Rezoning Transportation Analysis

Petition Number: #2022-048

From: Jake Carpenter, PE

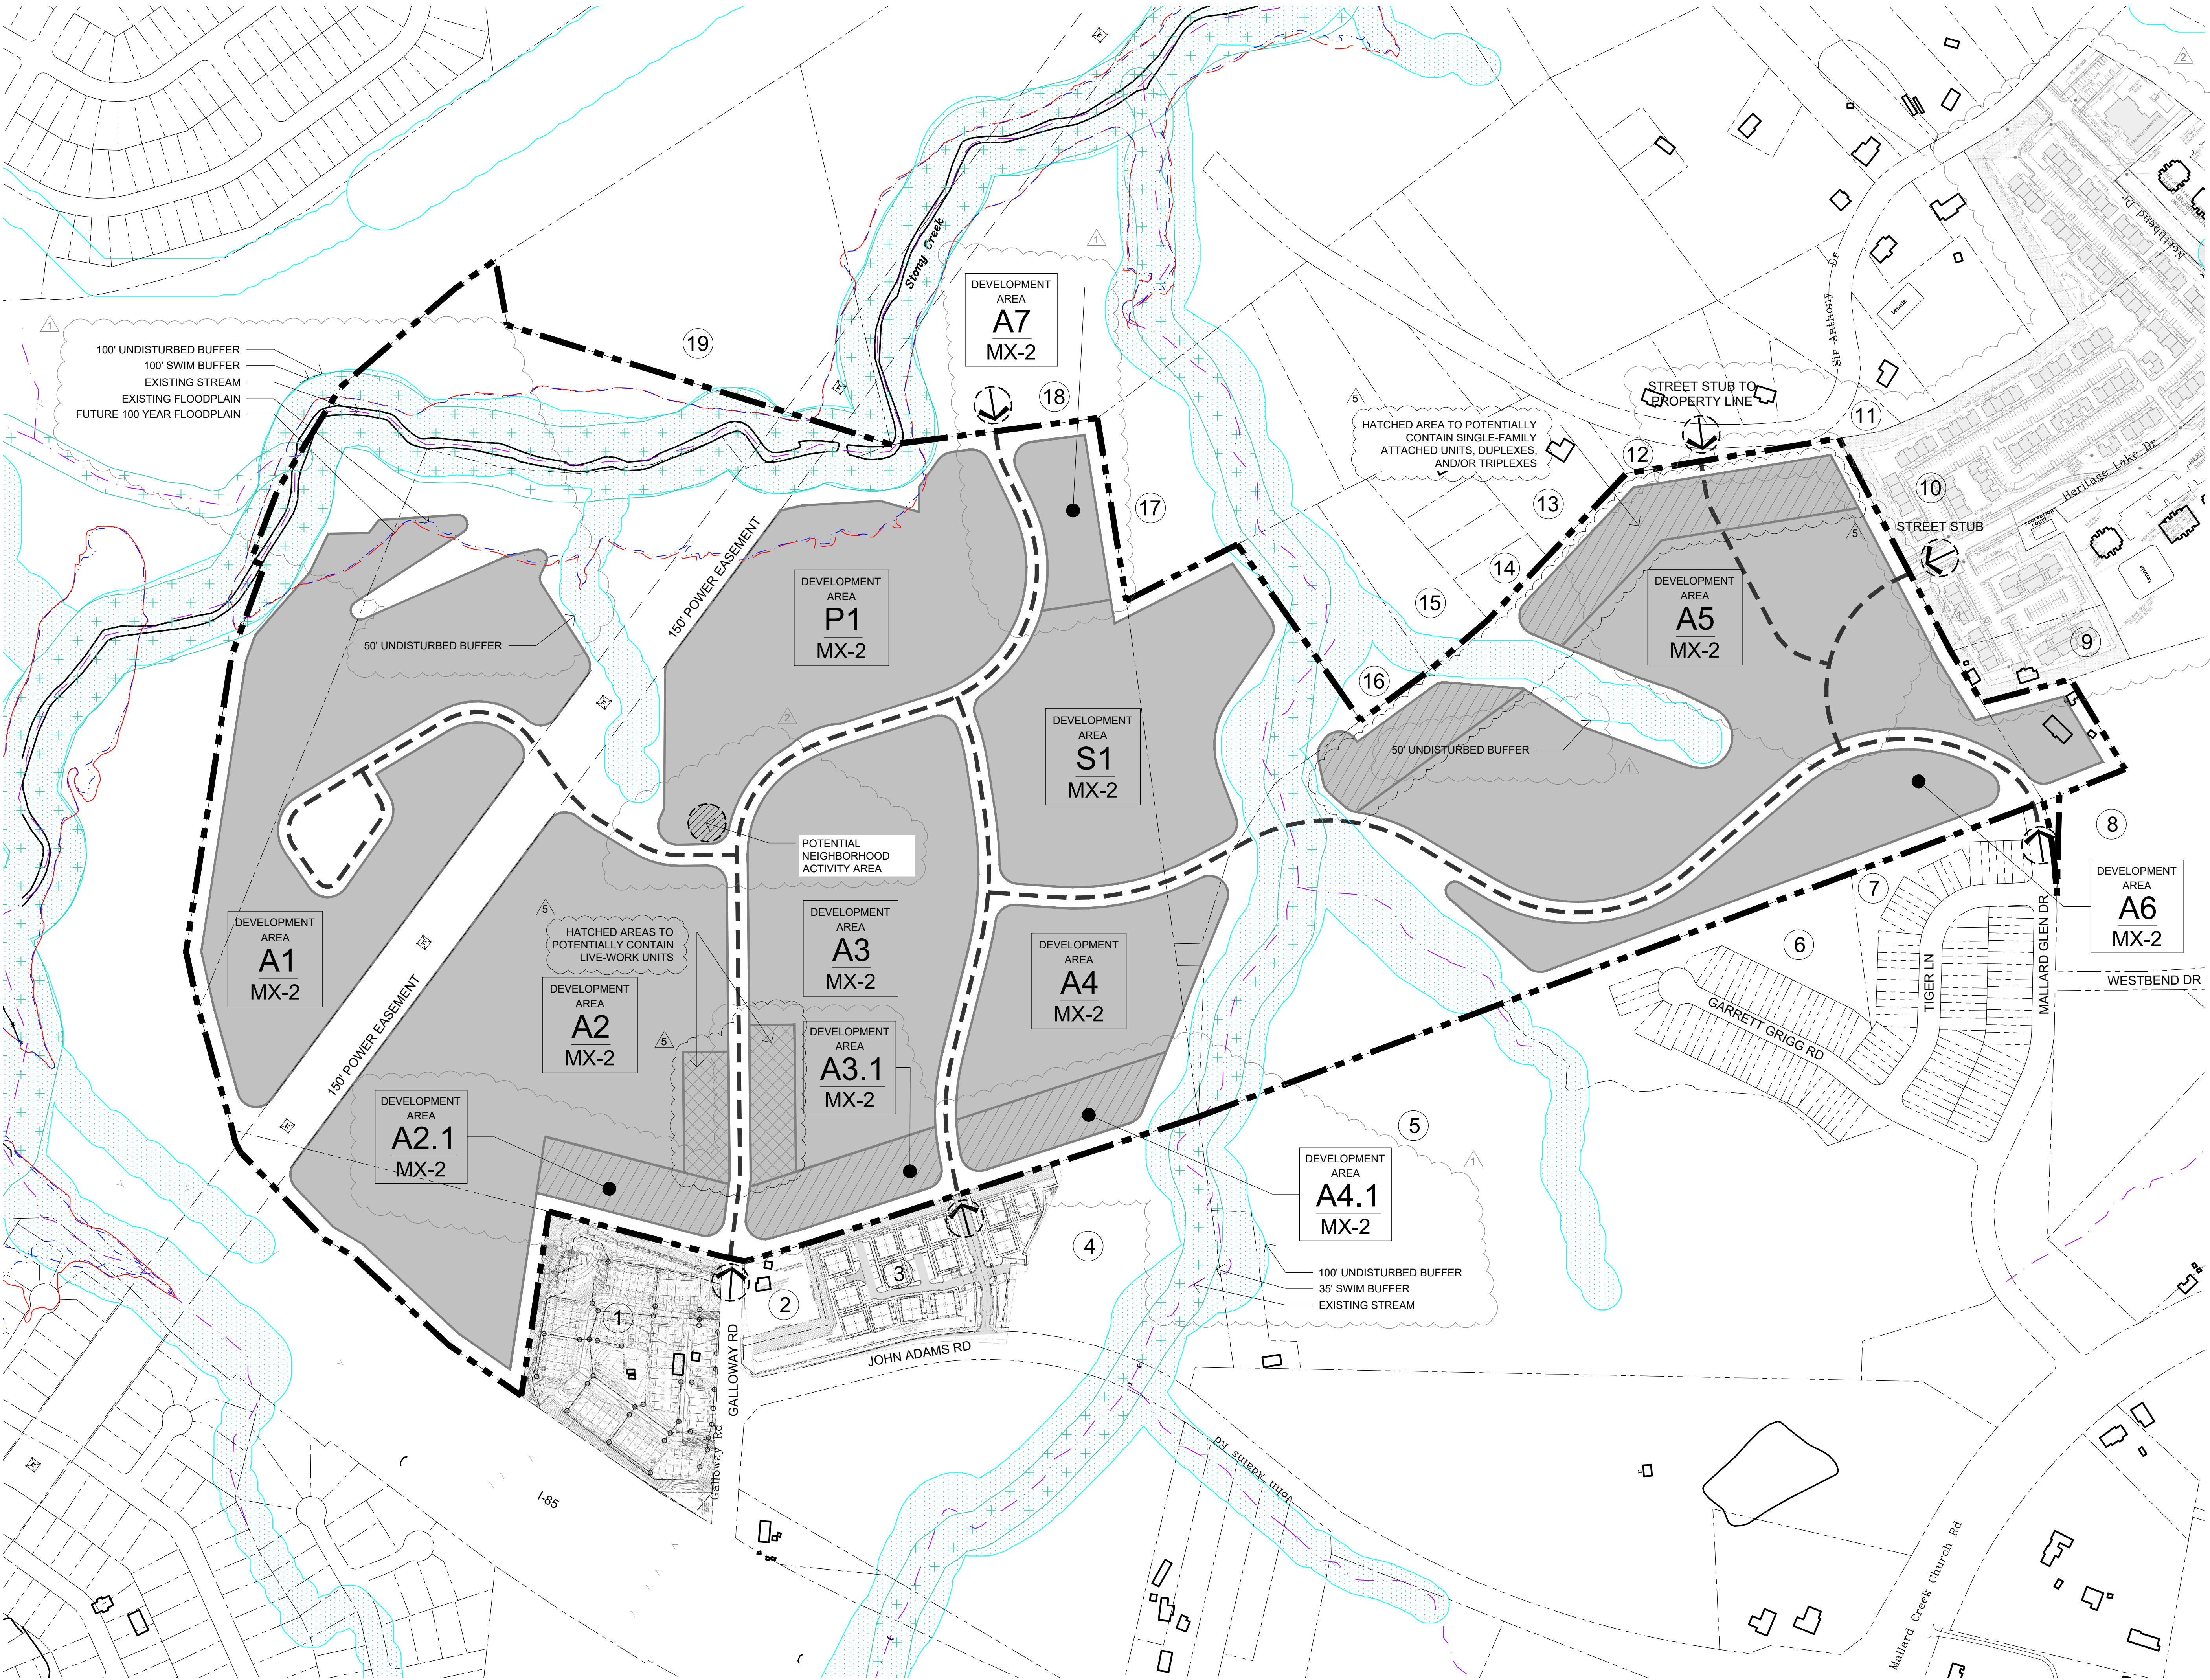
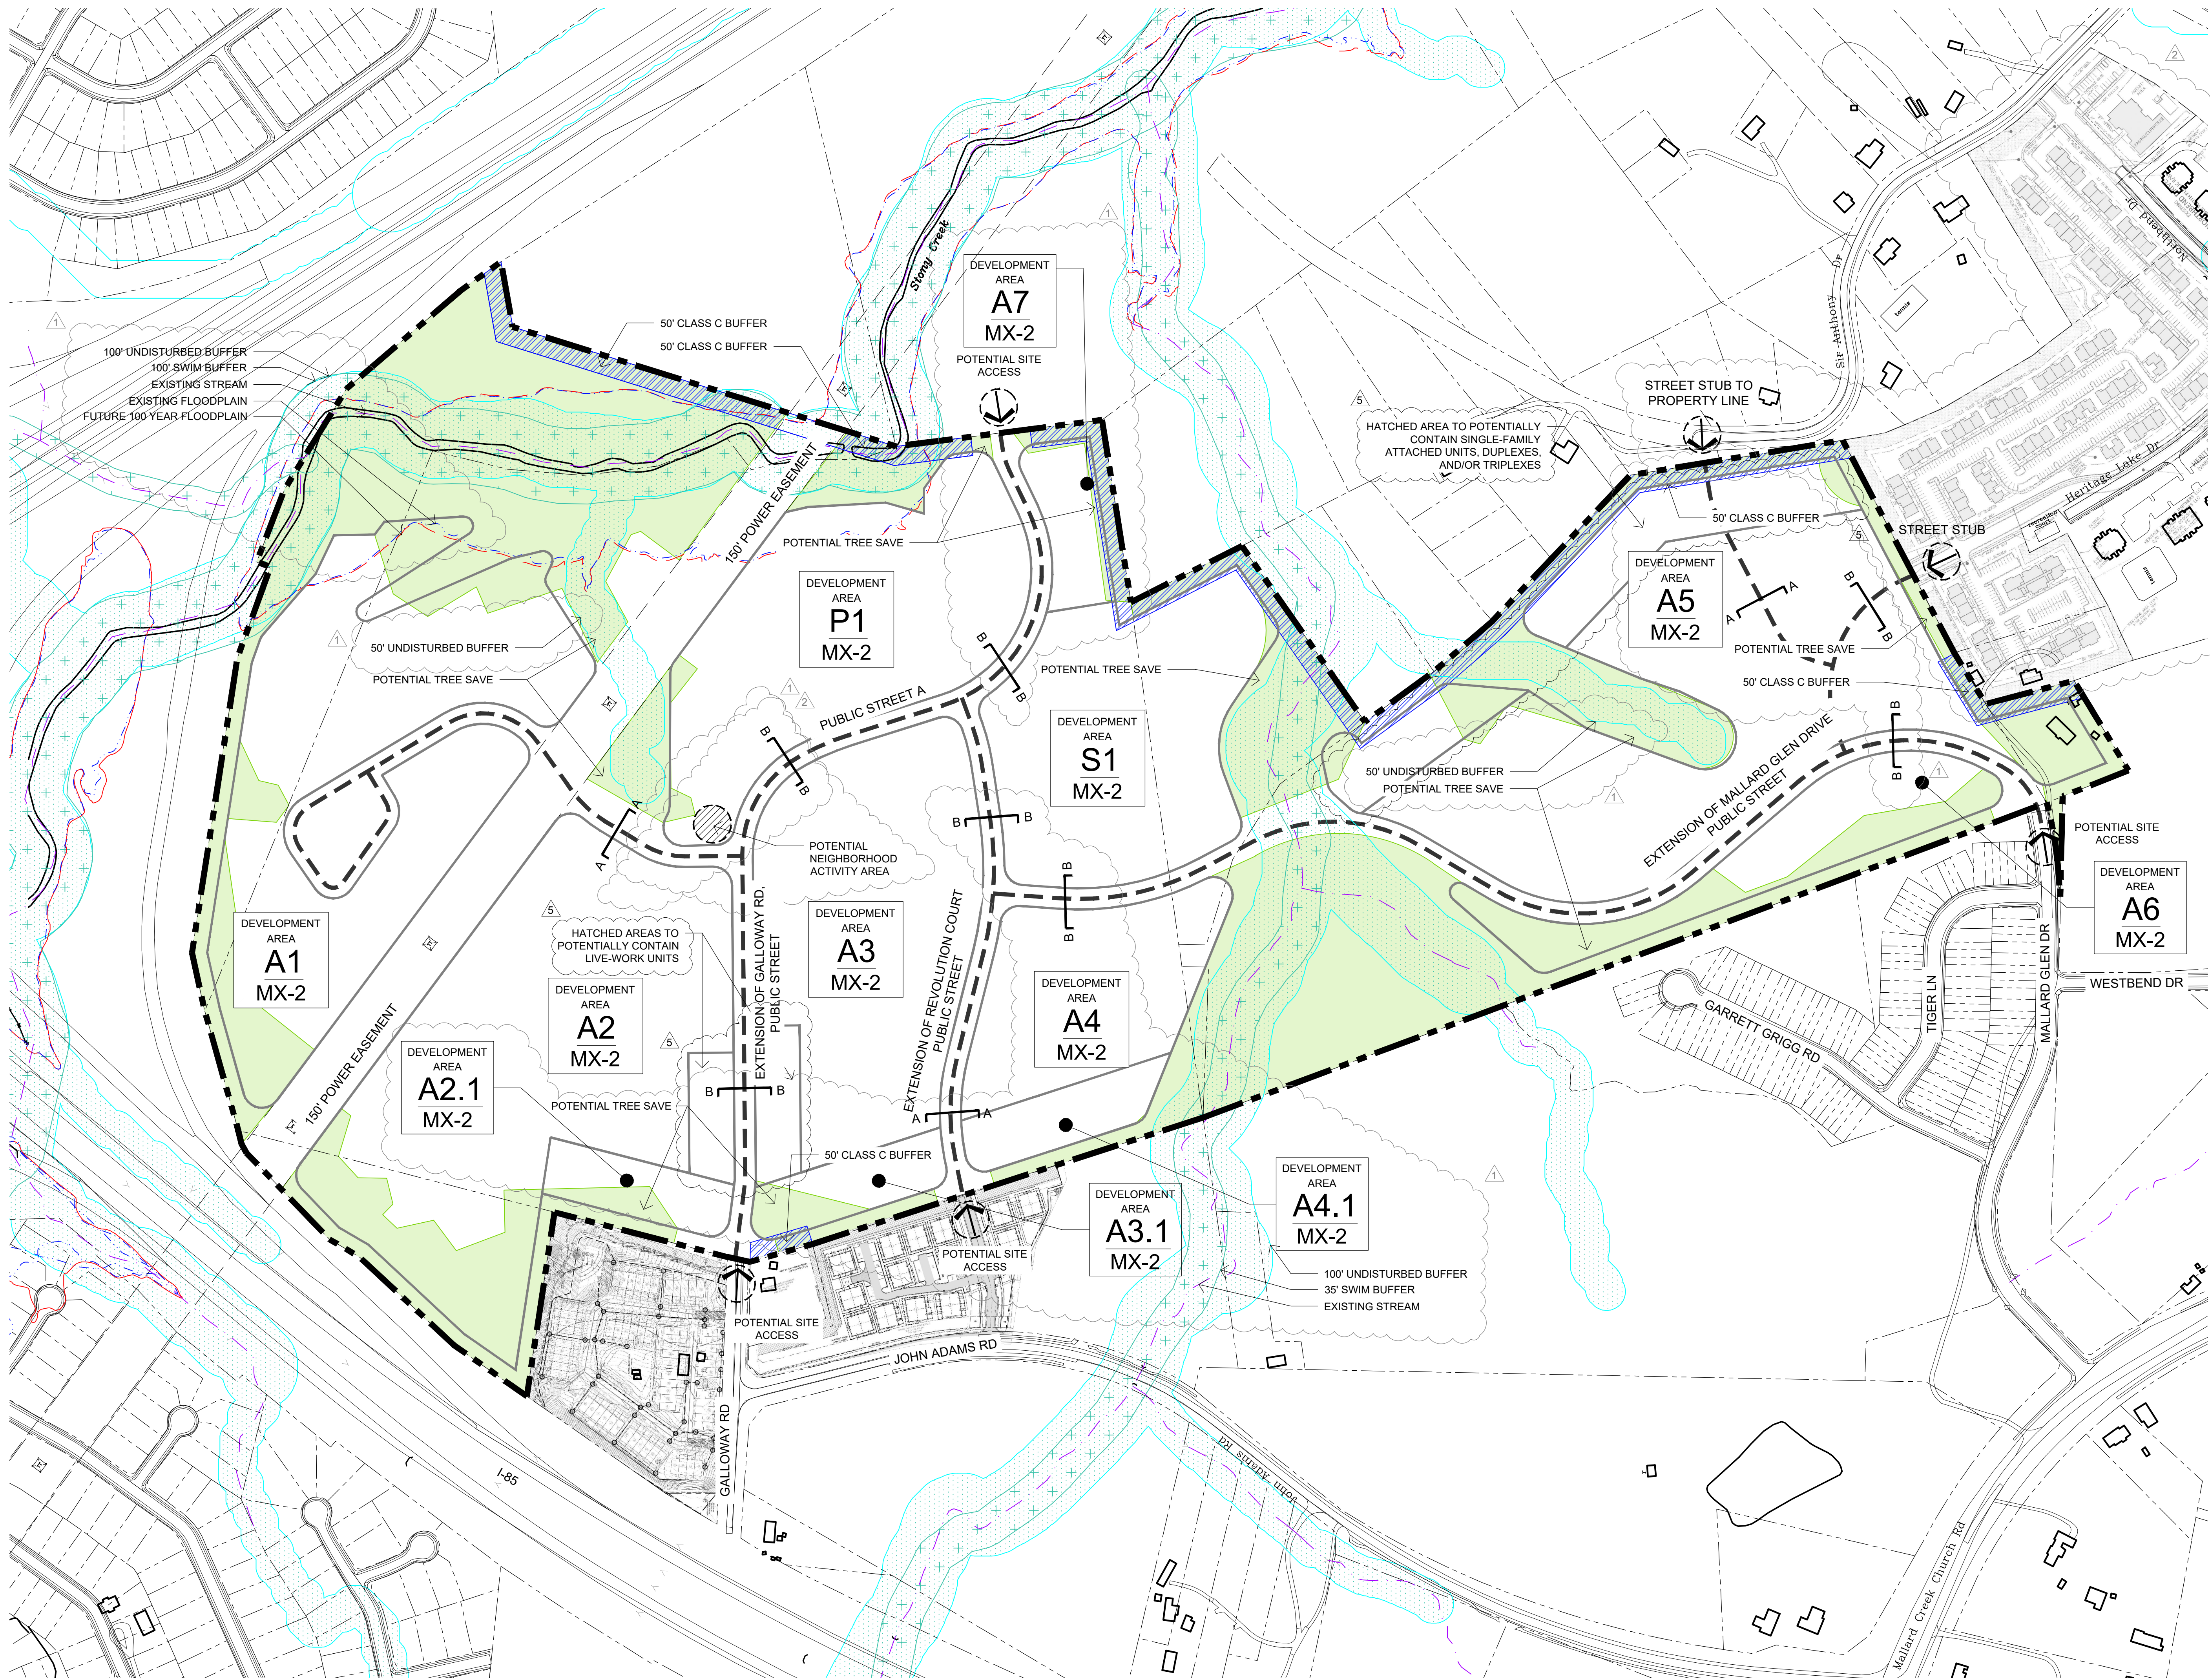
Updated Comment 04-06-23: Revise site plan conditional notes to include final improvements identified in the TIS.

2. **New CDOT COMMENT 04-06-23:** Revise site plan and conditional notes by committing to upgrading Northbend Drive and Heritage Lake Drive to public street standards.
